From: Maria Tomalova
Sent: 17 June 2022 11:44
To: Planning.Responses
Subject: FW: LU/124/22/PL and LU/125/22/PL

He is happy to discharge conditions 3 and 4 and for condition 6 (boundary treatment) we would request your email with bullet points stating;

Drawing Name
**Location and Block Plan
Discharge of Conditions**

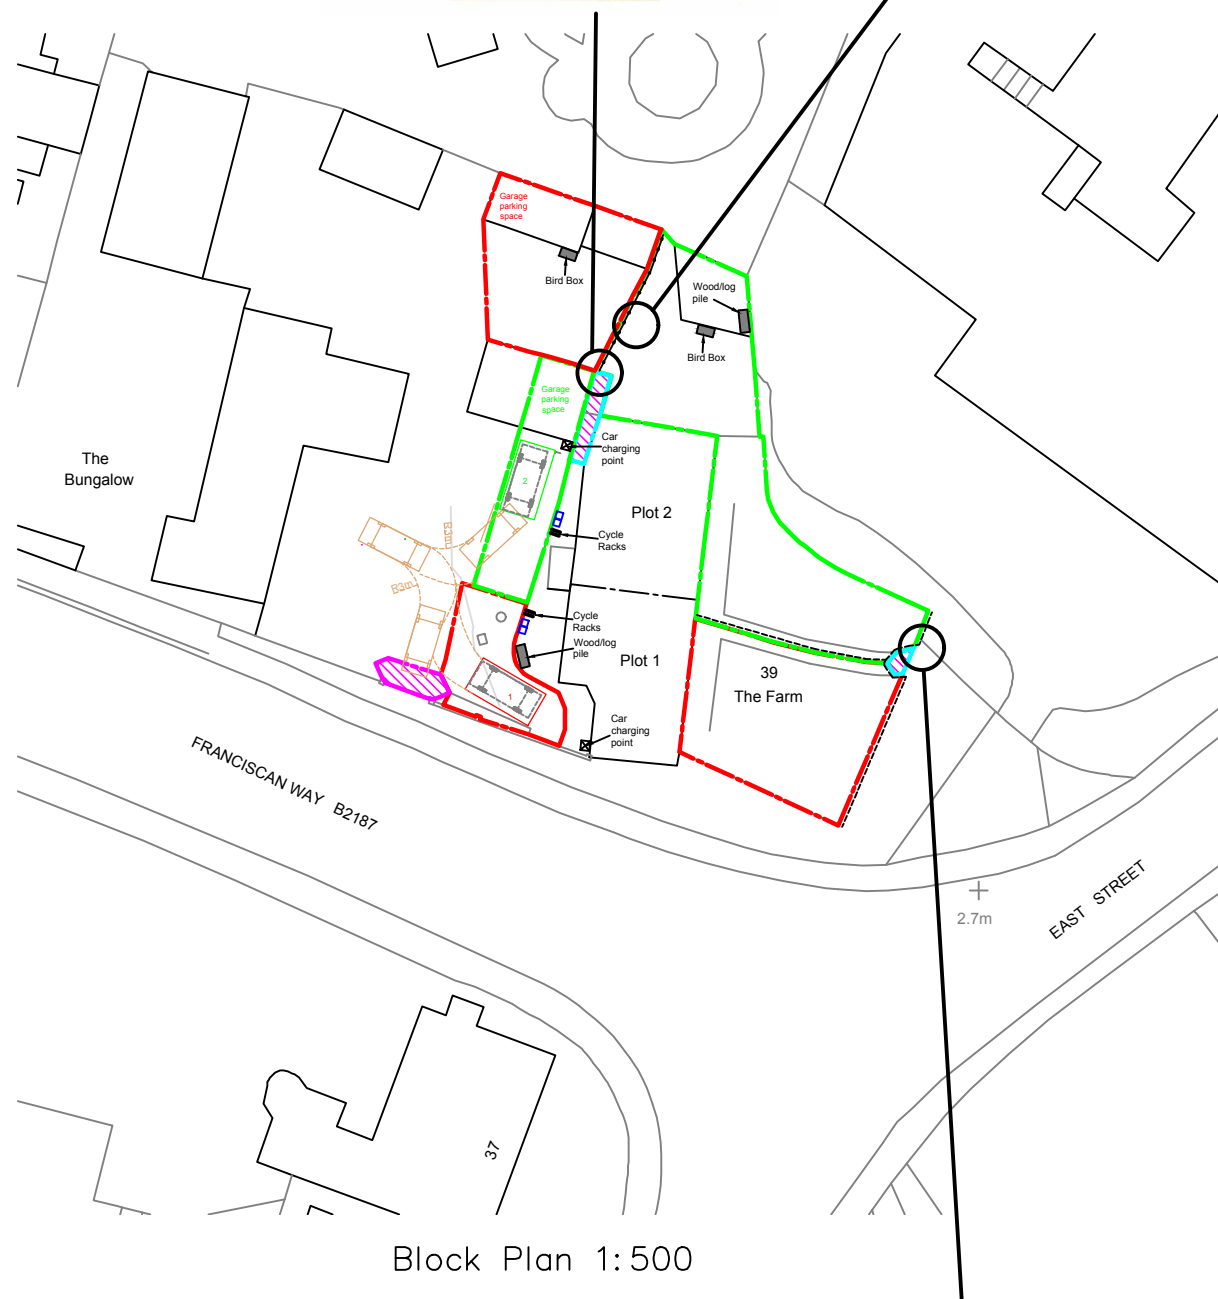
- Location, we would prefer behind the flint wall, protruding the wall up to 0.5m within a reasonable (maintainable) distance from the wall.
- Material and finishes, we would prefer timber, deep brown.
- The gaps in an existing hedgerow/shrub planting (behind the proposed fence) would be filled.

- 1) Location – the fence will be behind the flint wall (flint wall will be visible from the main road). It will be away from the wall ensuring the wall is not being pressed against ensuring the wall is maintainable. The Picket Fence will be a meter high which means it will protrude only 0.5 metres above the wall. This means only 0.5meters of the fence will be visible from the main road.
- 2) The picket fence will be made of durable pine/other suitable wood which we ensure is treated to protect against rot and decay. This will be painted in deep brown.
- 3) We are happy to fill any necessary gaps with hedgerows/shrubs (behind the fence).
